From: Bloomer, David <David.Bloomer@lancashire.gov.uk>
Sent: 28 March 2018 09:07
To: Stephen Kilmartin
Cc: LHS Customer Service
Subject: FW:app3/2018/0143 The Barn, Shawhouse Farm

From: Joshua Southern [mailto:joshua.southern@sunderlandpeacock.com]
Sent: 27 March 2018 17:04
To: Stephen Kilmartin ; Bloomer, David
Cc: Philip Cottier ; Paul Gudgeon
Subject: RE: The Barn, Shawhouse Farm (app18/0143)

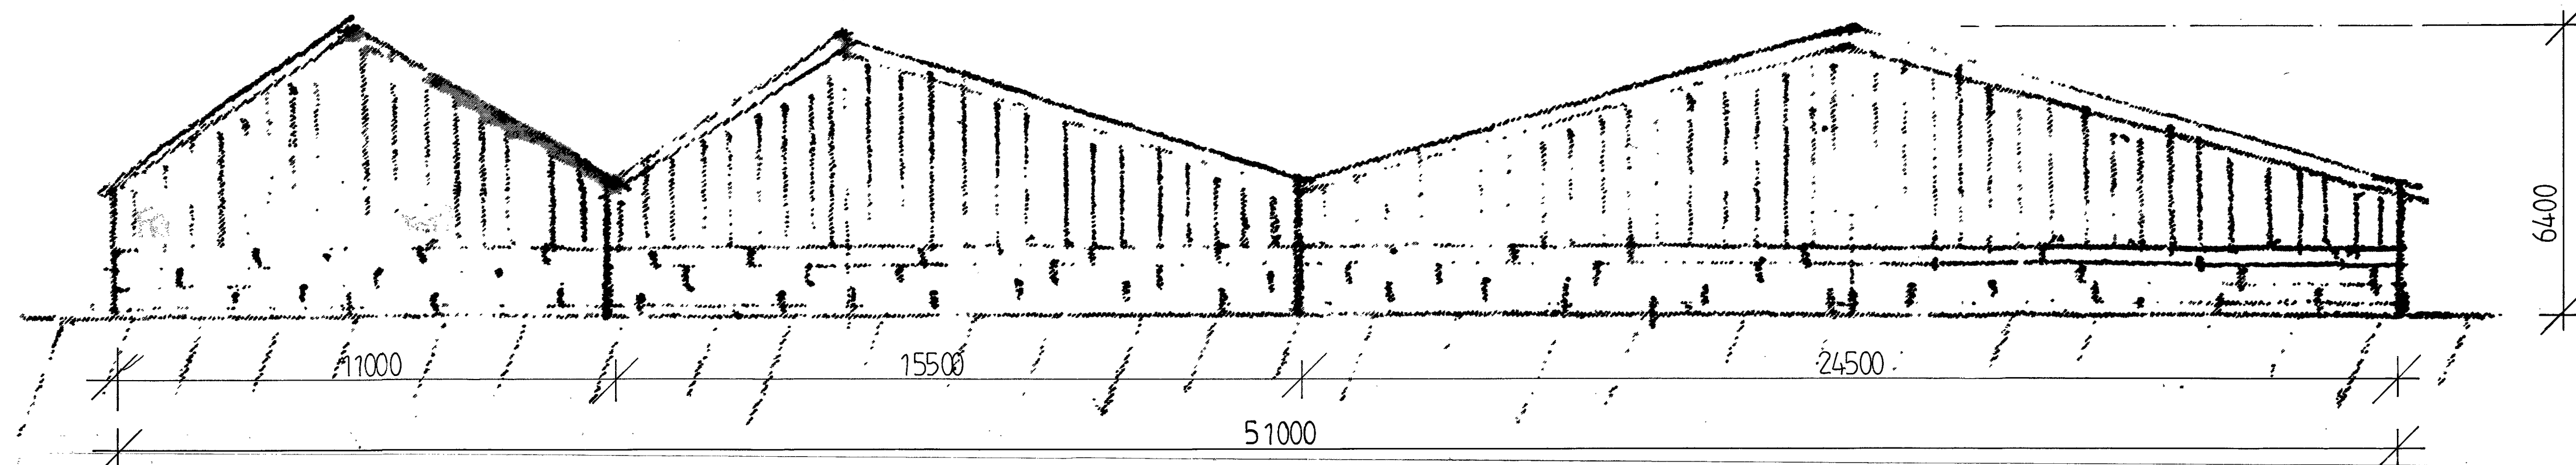
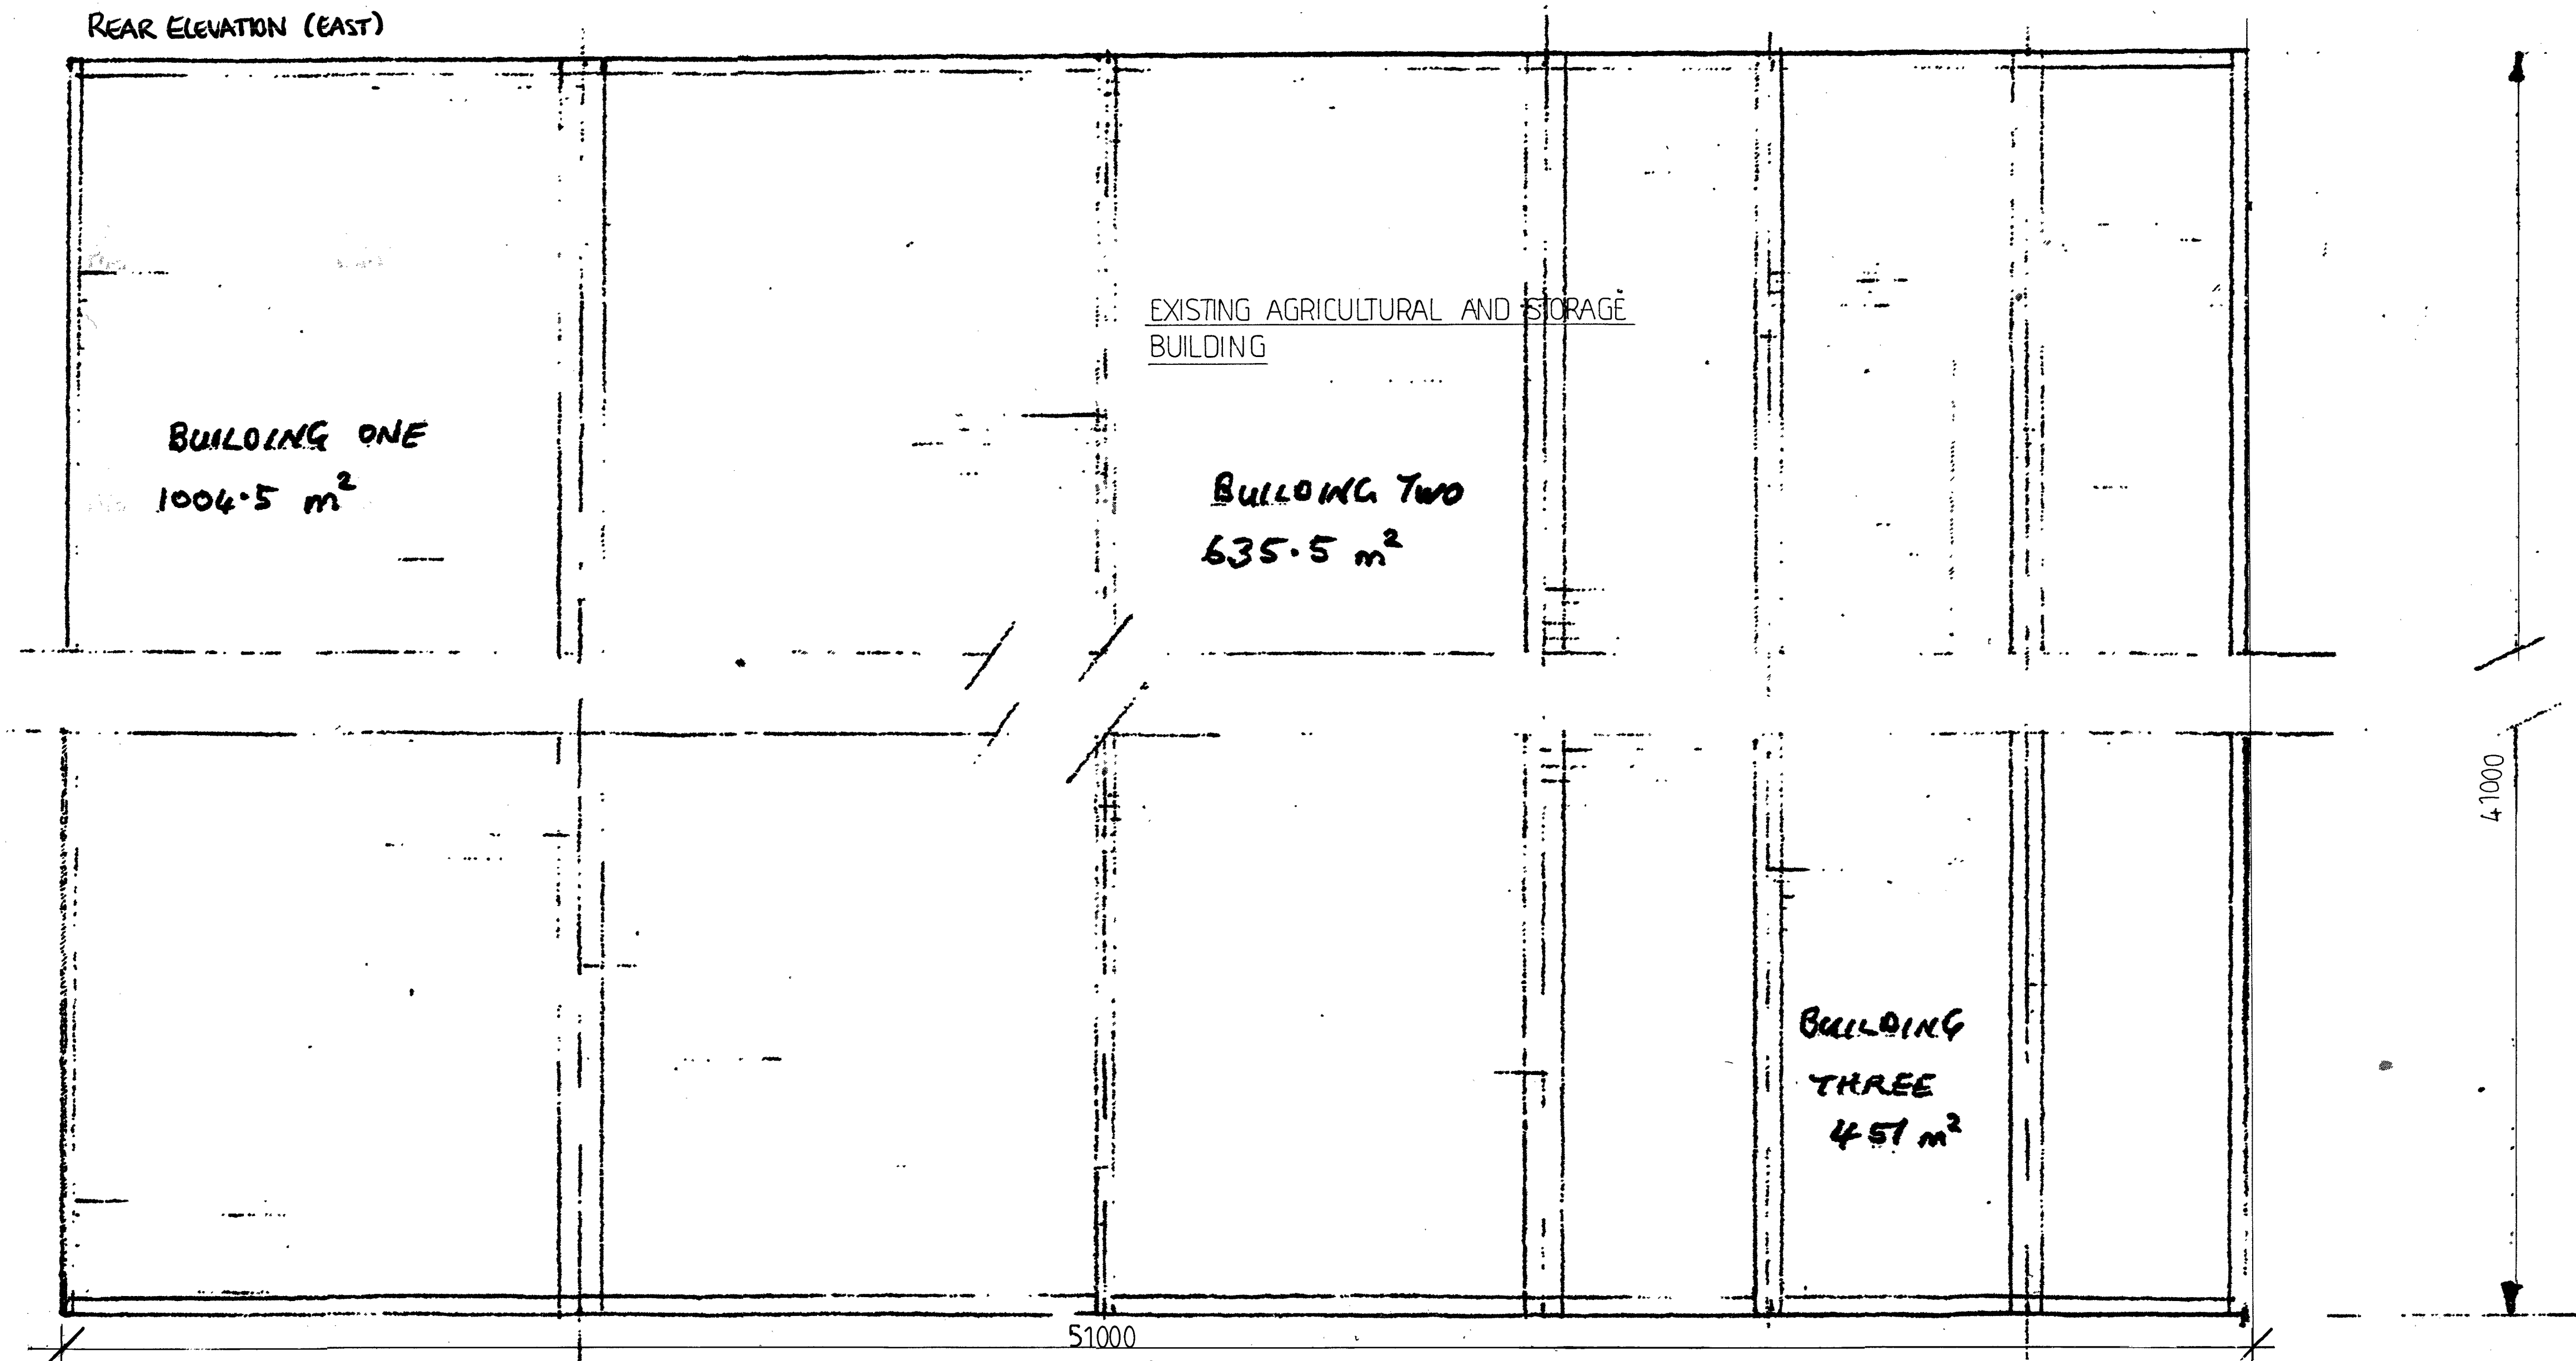
I am awaiting updated drawings for the entirety of the buildings, can you inform as to when these will be forthcoming?

Please find enclosed drawings showing the entirety of building on both Existing (01) and Proposed (02). The heights and overall building size are fully dimensioned. Door openings are clearly annotated on the front dimensions. Due to us inheriting this drawings from the client there are no side elevations, however they are just cladded walls and roofs with no changes proposed. The application relates to change of use with no material changes to the existing building.

Drawing Title  
**PROPOSED**  
Plans and Elevations of former  
agricultural building now proposed to  
have change of use to B8 Class-Storage.

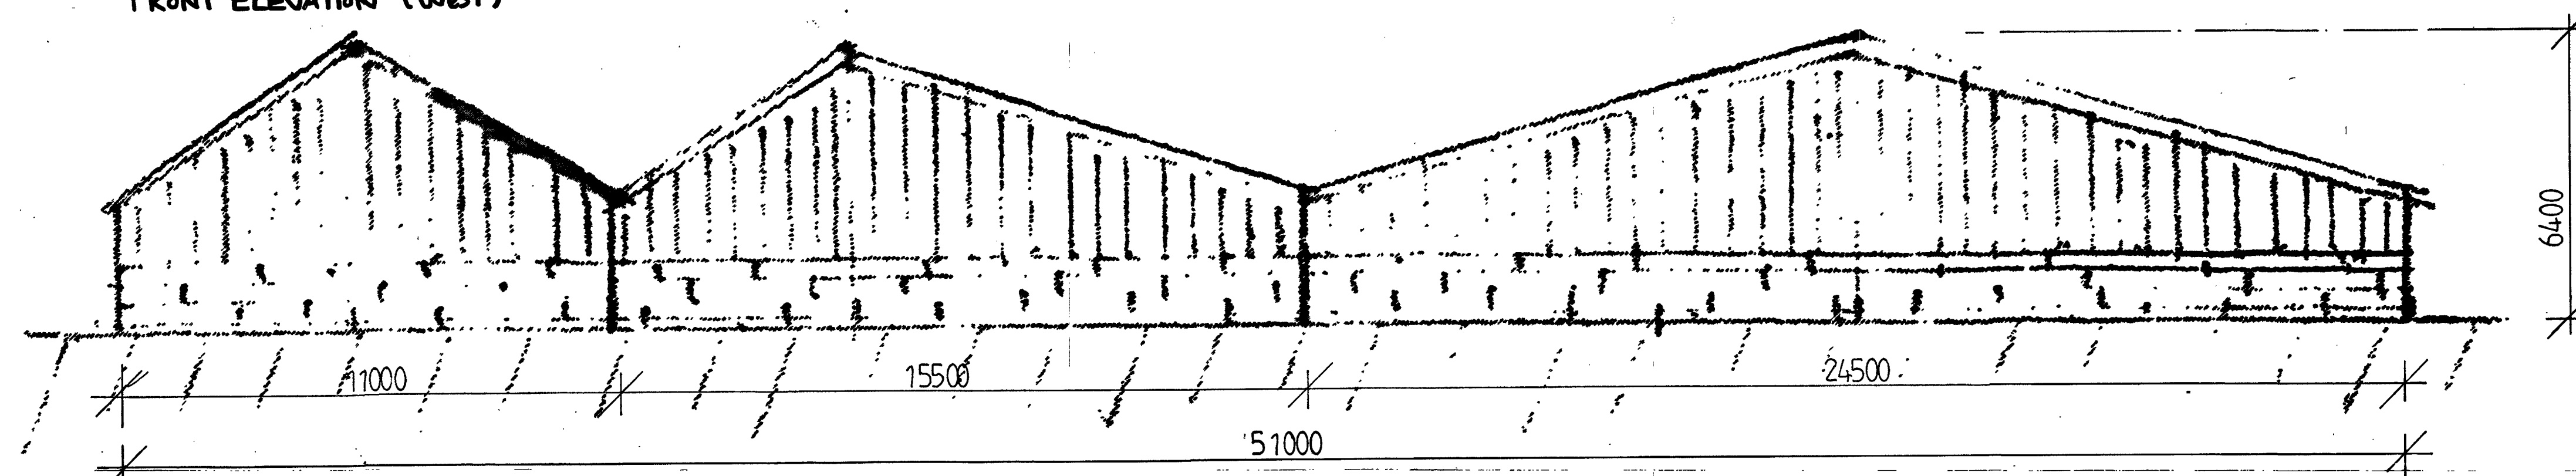
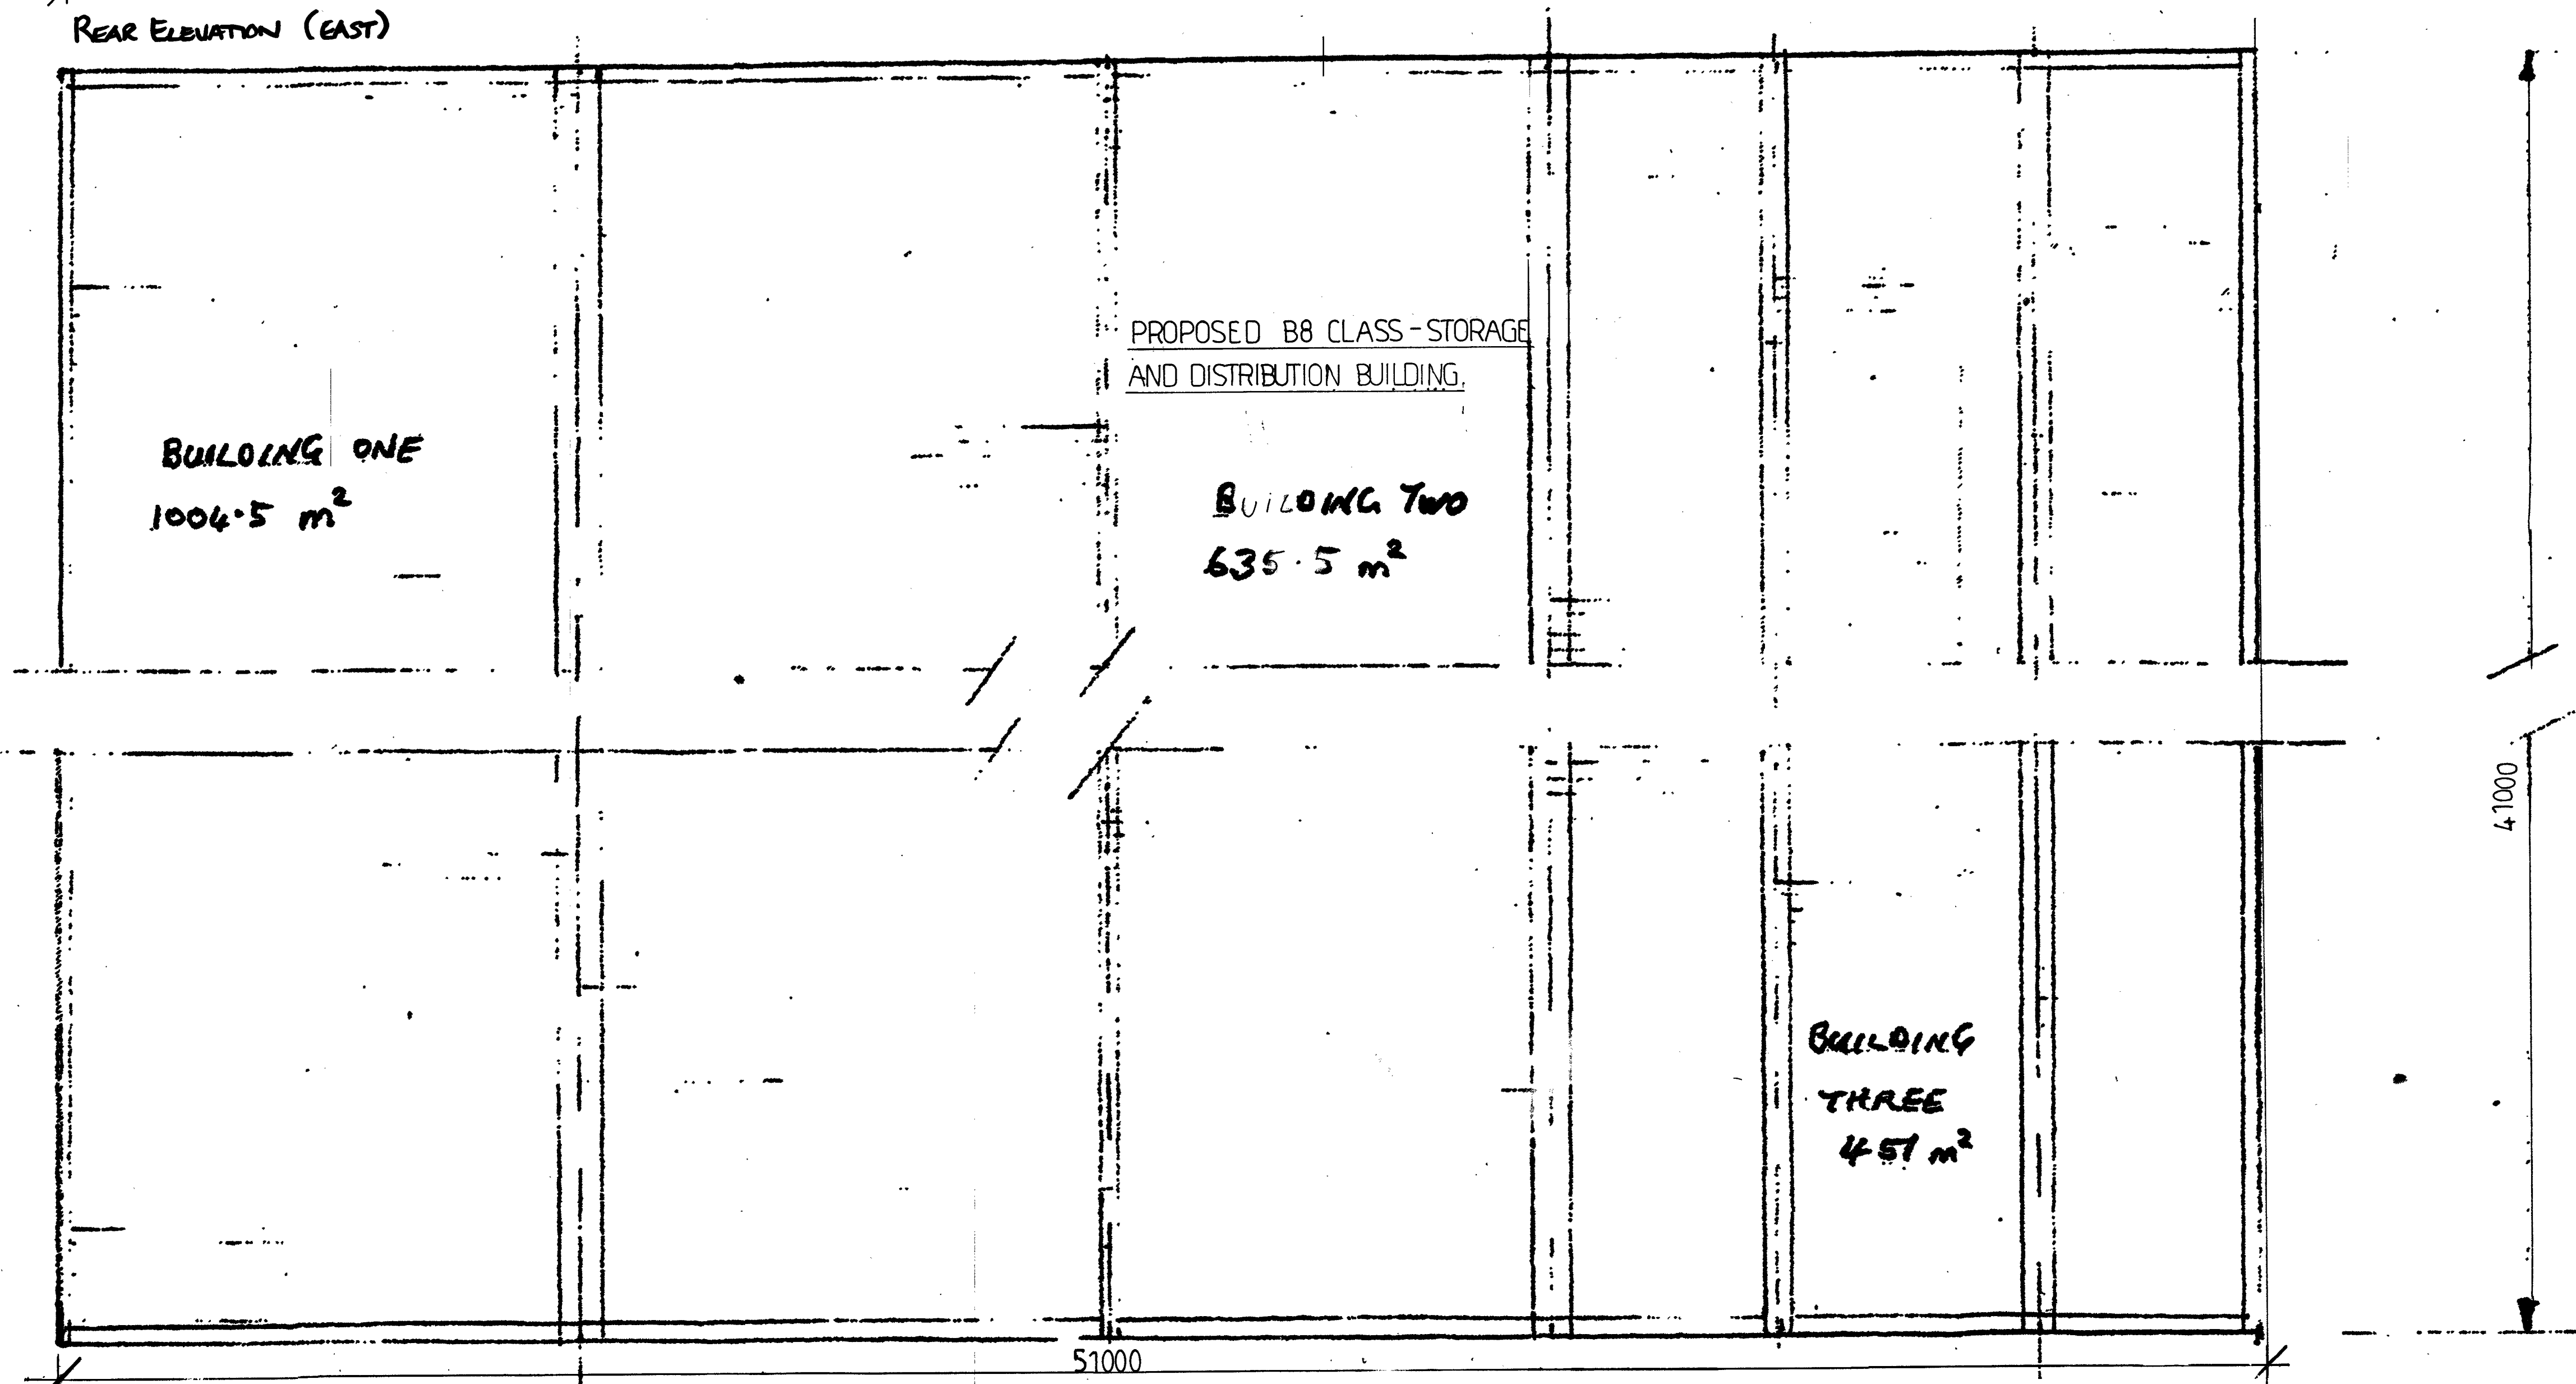
I note the three buildings now have named operators. Can you clarify the nature of the functions to be undertaken on site. Can you also clarify whether the area outside of the buildings will be resurfaced and what other enabling works are required?

With regards to the named operators see drawing reference - Proposed -02- Site Usage. To clarify the functions of each business.

Purple - The British Christmas Tree Company use it for the storage of its plants.

Green - TNT Scaffolding LTD – storage of scaffolding.

Yellow - David Holmes construction Limited – storage of small scale building materials. Large building materials will go direct to site.

The existing business use it for storage and distribution , no direct sales and manufacturing processes.
